Recommendation Report for Planning Permission for Works or Extension to a Dwelling

REF NO: BR/149/20/HH

LOCATION: 11 Westingway
Bognor Regis
PO21 2XU

PROPOSAL: Extension of existing garage to be an Oak framed garage with pitched tiled roof including 2 skylight windows, clad in non combustible treated wood cladding or composite cladding and entrance enclosed withing existing garden.

Floorplan and window placement.

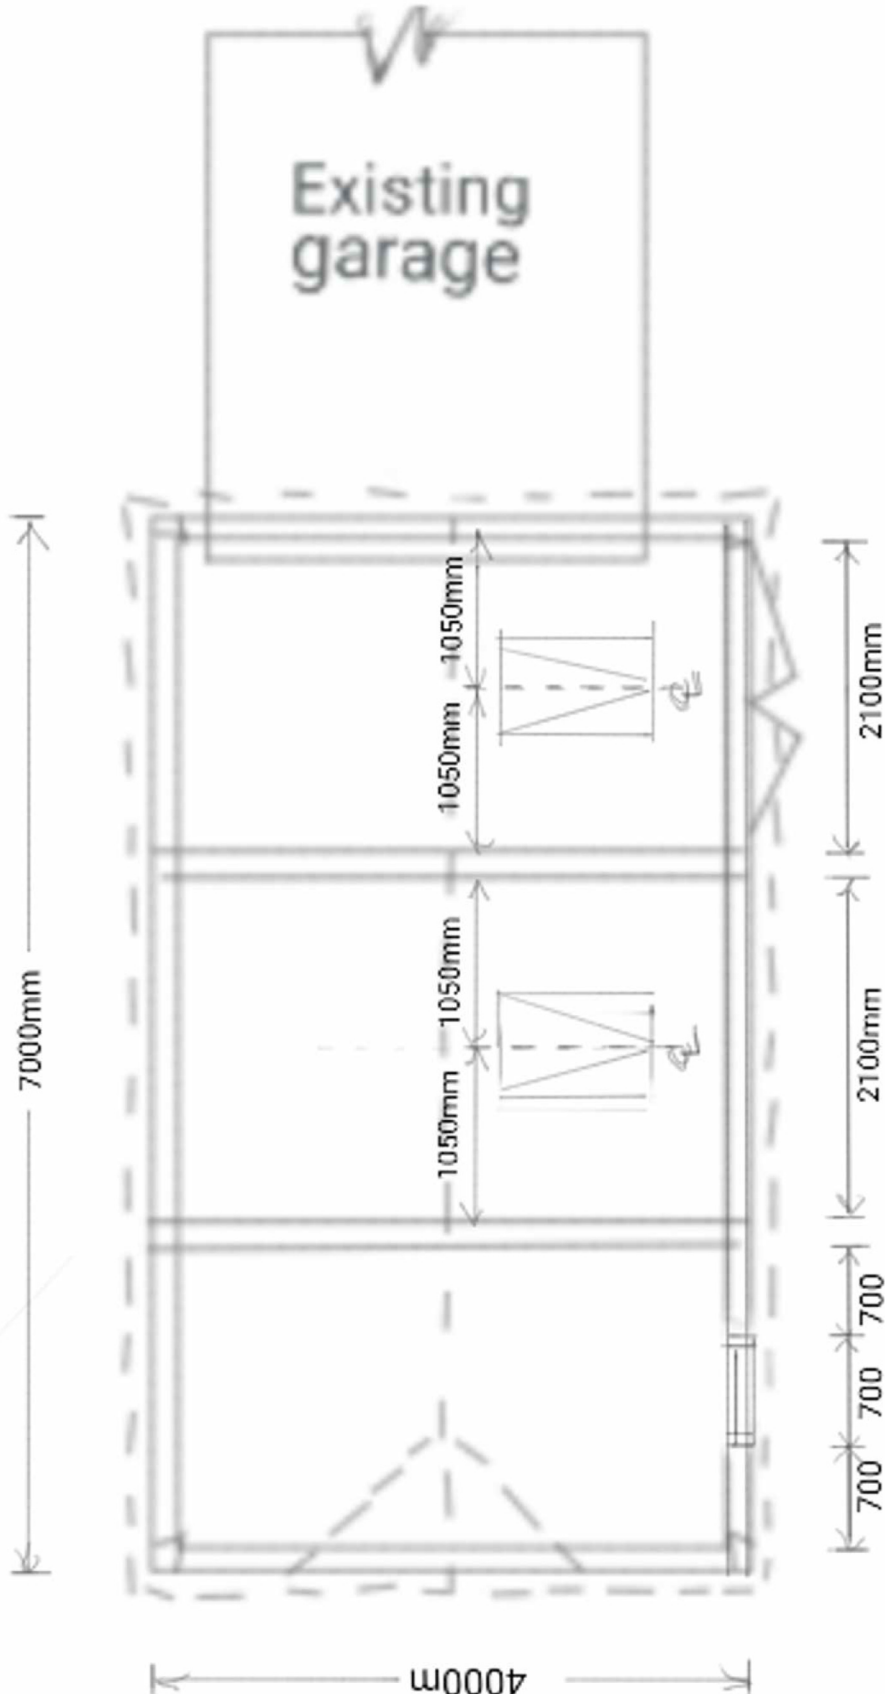
The garage is set back from the road retaining around 7m to the street frontage and the development would extend the garage to infill this gap, running along the north eastern elevation meeting with the boundary footpath. The extension will be an oak framed structure with tiled roof. The materials are acceptable. The garage will have a height of 3.9m with a barn hip to the front with a width of 4m.

There are no other examples of outbuildings located at the street frontage with the development sited significantly forward of the established development line. As a result of its siting when viewed from the road the extension will be visually prominent and appear as an unduly dominant feature in the street scene.

As a result of the siting of the garage and with no similar outbuildings visible to the street frontage it is considered to give rise to an adverse impact upon the street scene and spatial pattern of the area, in conflict with DDM1 (1) of the Arun Local Plan.

The garage will run along the boundary to the north east which consist of a fence reducing in height from around 1.8m to approximately 1.2m as it extends towards the street scene. The garage will extend along this boundary with a depth of 7m.

There are no openings to the north eastern side and therefore no adverse overlooking with doors and velux fronting the garden of the host dwelling.

There is no garage door proposed to the road frontage and therefore it does not appear as the structure would be used as a garage. The extension would therefore remove the access to the existing garage and ultimately an off road parking space. There is however sufficient on street parking and this is not considered to give rise to highway or parking issues.
